**Post Point CHN 215
Hertfordshire County Council
County Hall, Pegs Lane
HERTFORD SG13 8DN**

Date 12 December 2019

RE: 6/2019/2760/OUTLINE – Colesdale Farm, Northaw Road, West Northaw, Potters Bar, EN6 4QZ

Following a review of the Flood Risk Assessment and Drainage Strategy prepared by EAS, reference 2088/2019, dated October 2019 submitted in support of the above application, we can confirm we have no objection on flood risk grounds and advise the LPA that the proposed development site can be adequately drained and mitigate any potential existing surface water flood risk if carried out in accordance with the overall drainage strategy.

Appendix: M- SuDs Layout

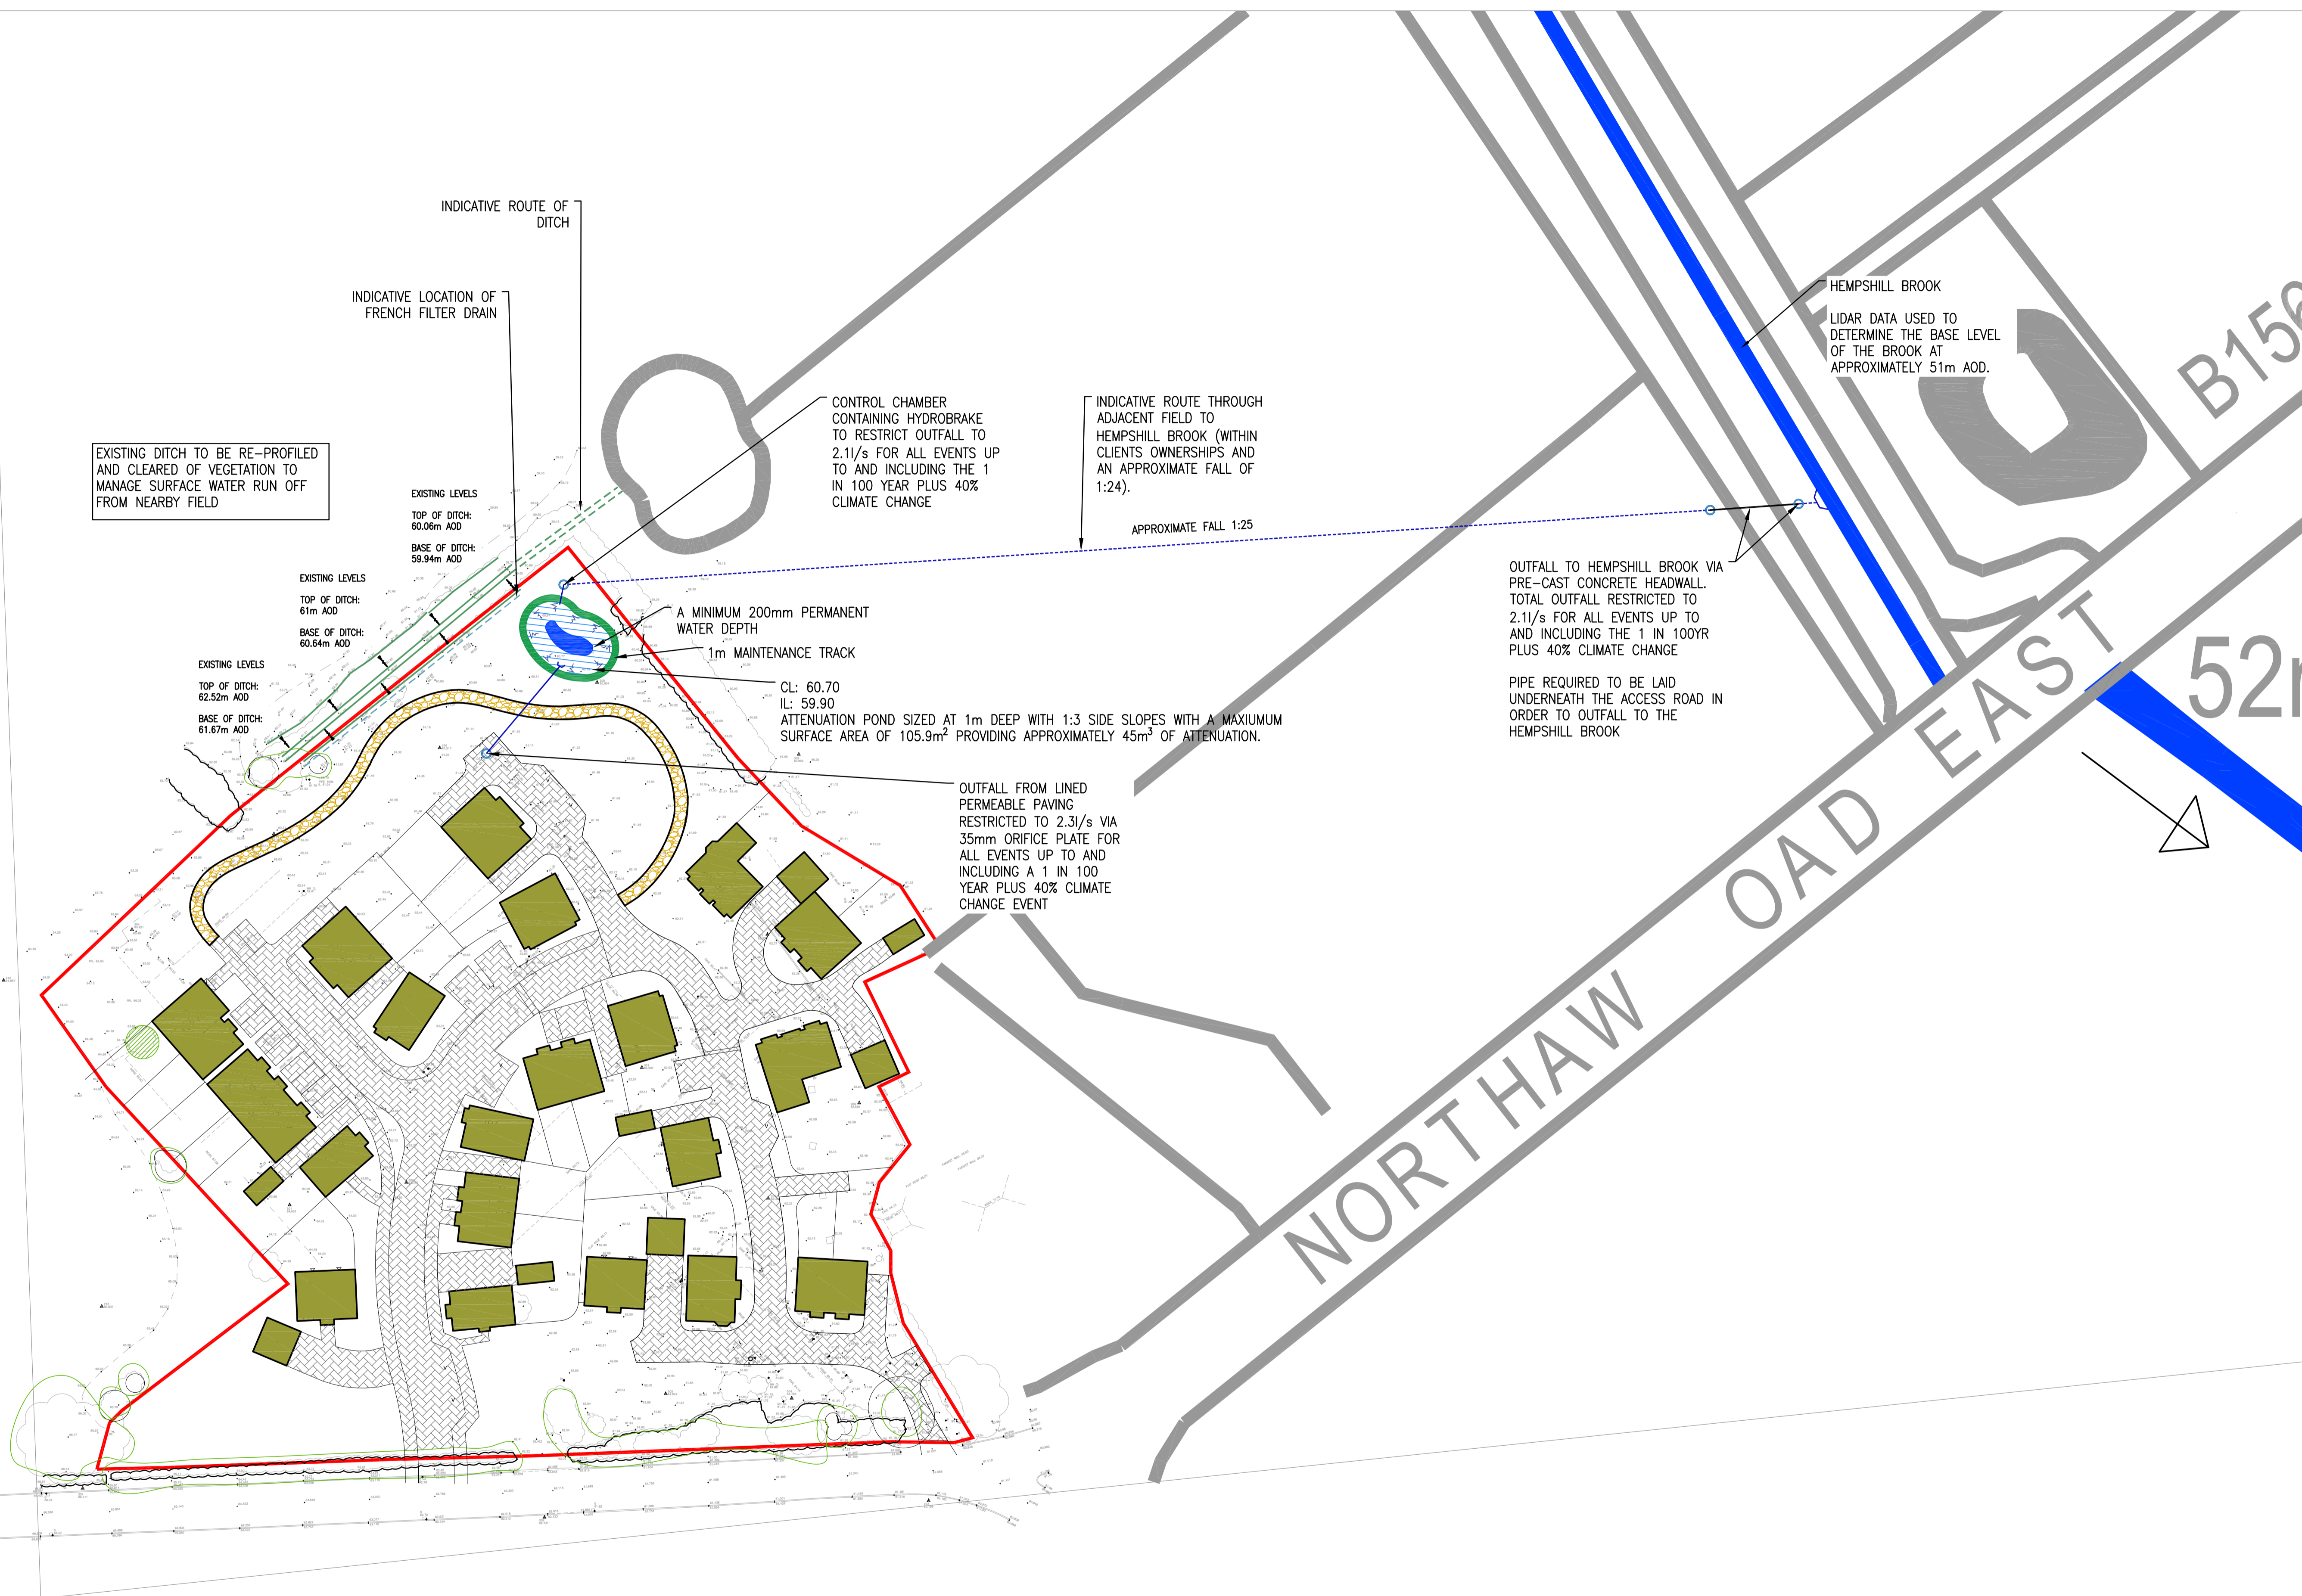
We understand it is proposed to drain the site using the existing ditch at the northern boundary of the site, lined permeable paving for the internal road, footpaths and parking areas and an attenuation pond in the north-eastern corner of the site. The site is proposed to discharge to Hempshill Brook at the greenfield Qbar rate of 2.1l/s for all events up to and including the 1 in 100 + 40% climate change storm.

1. Detailed, updated post-development calculations/modelling in relation to surface water for all rainfall events up to and including the 1 in 100 year return period, this must also include a +40% allowance for climate change.
2. A detailed drainage plan including the location and provided volume of all SuDS features, pipe runs and discharge points. If areas are to be designated for informal flooding these should also be shown on a detailed site plan. This should also include details of the proposed mitigation measures at the north of the site.
3. Exceedance flow paths for surface water for events greater than the 1 in 100 year including climate change allowance.

4. Detailed engineered drawings of the proposed SuDS features including cross section drawings, their size, volume, depth and any inlet and outlet features including any connecting pipe runs. This should include details regarding the connection into the existing ordinary watercourse.
5. Final detailed management plan to include arrangements for adoption and any other arrangements to secure the operation of the scheme throughout its lifetime.

We note that the proposed outfall to Hempshill Brook, a main river, would be in Flood Zone 3. Therefore, we advise that the LPA consult the Environment Agency regarding any requirements they may have for this application.
